Preliminary Acceptance Punchlist
El Paso County – Department of Public Works - Stormwater Section

Project Name:	Widefield Park & Rec Improvements
EDARP Filing Number(s):	PPR2213, CON2261
ESQCP Number:	ESQ2250
Attendees:	DPW SW: Natasha Grimaldo, Ben Jones, and Mikayla Hartford DPW Development Services: David Parkerson and Brad Walters Developer: Justin Harrod
Date of Walk-Thru:	08-22-2023
Walk-Thru Number:	1 st

C8.1

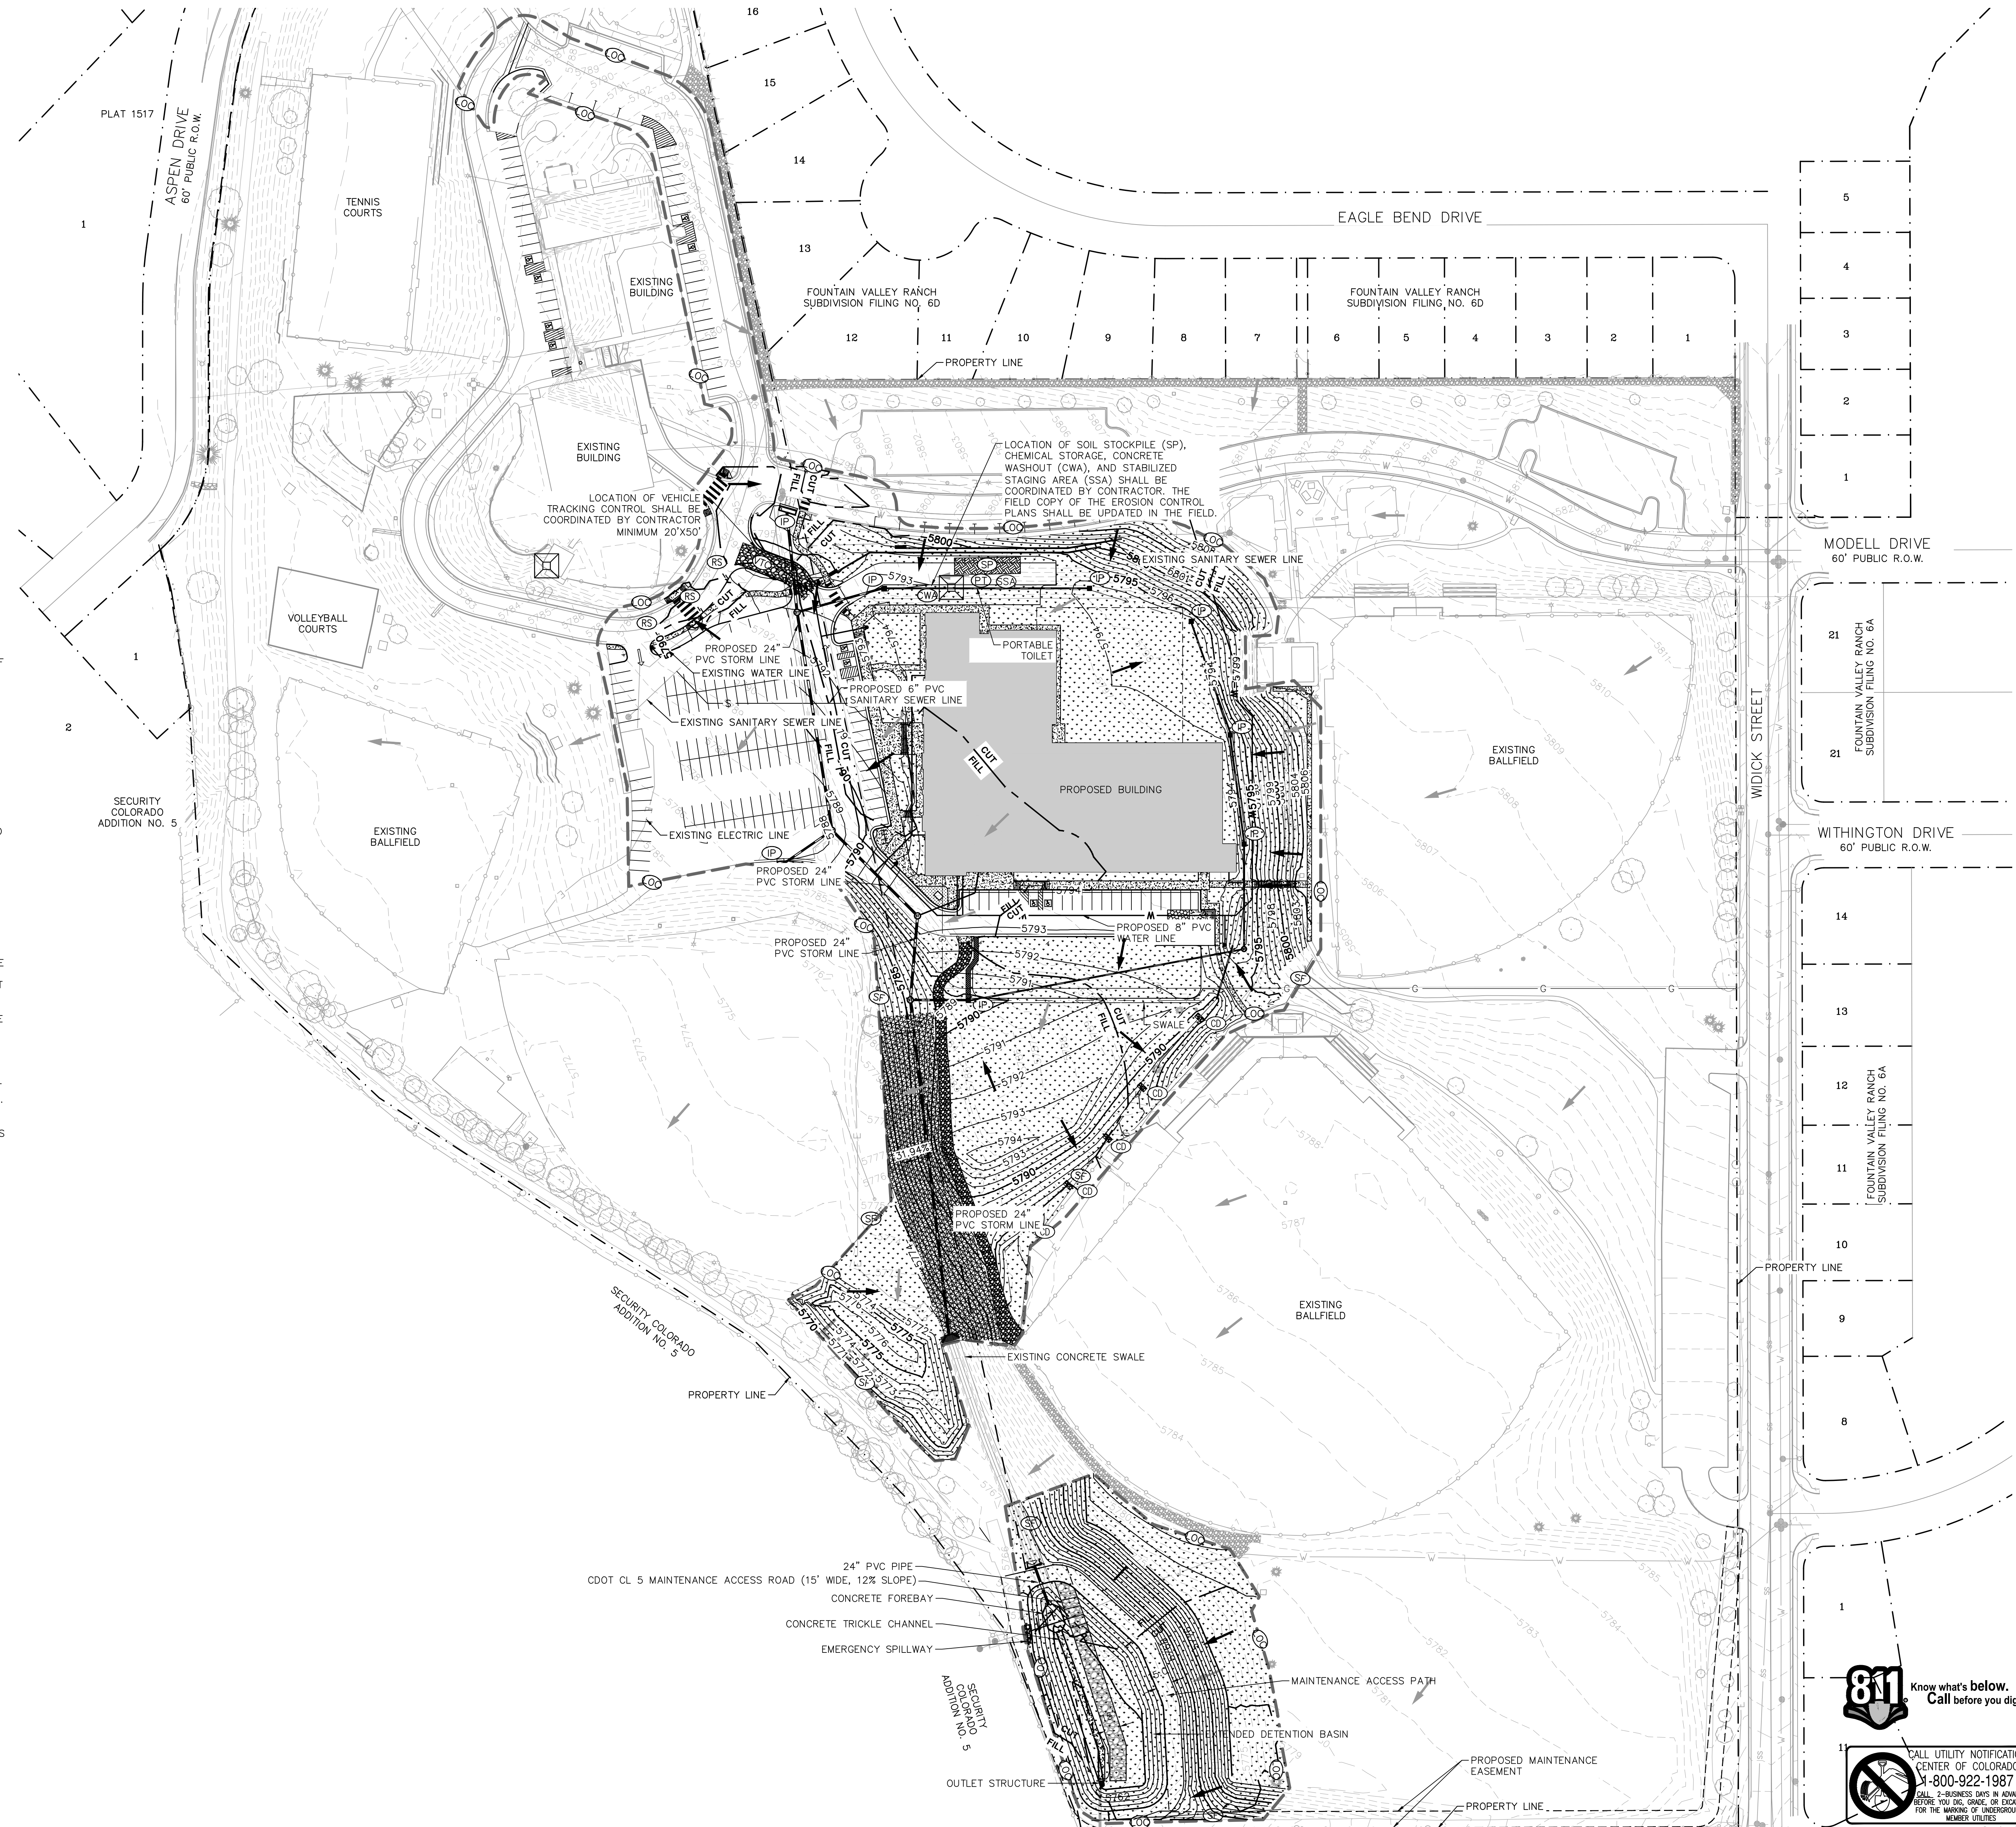
- South of building: Install check dams within the drainage ditch per the approved plans. Reference sheet C8.2 of the Grading and Erosion Control Plans.
- Above Grouted riprap: Replace 12" pipe with 24" RCP with a FES per the approved plans. Reference sheet C8.2 of the Grading and Erosion Control Plans.
- South of building: Remove and replace grouted riprap with 18" Type M riprap pad per the approved plans and for positive drainage and erosion prevention. The riprap needs to be shaped for positive drainage, currently the

grouted riprap does not have a consistent shape with grouted rocks raised in the middle of the rundown. The riprap also should be buried in the ground so that the riprap is flush with the ground. Currently the riprap is a foot above the ground which is contributing to erosion from splashover especially downstream where the rundown meets the concrete lined channel. Reference sheet C8.2 of the Grading and Erosion Control Plans.

Photo 1: South of building: Install check dams within the drainage ditch per the approved plans. Reference sheet C8.2 of the Grading and Erosion Control Plans.

Photo 2: Above Grouted riprap: Replace 12" pipe with 24" RCP with a FES per the approved plans. Reference sheet C8.2 of the Grading and Erosion Control Plans.

Photo 3: South of building: Remove and replace grouted riprap with 18" Type M riprap pad per the approved plans and for positive drainage and erosion prevention. The riprap needs to be shaped for positive drainage, currently the grouted riprap does not have a consistent shape with grouted rocks raised in the middle of the rundown. The riprap also should be buried in the ground so that the riprap is flush with the ground. Currently the riprap is a foot above the ground which is contributing to erosion from splashover especially downstream where the rundown meets the concrete lined channel. Reference sheet C8.2 of the Grading and Erosion Control Plans.
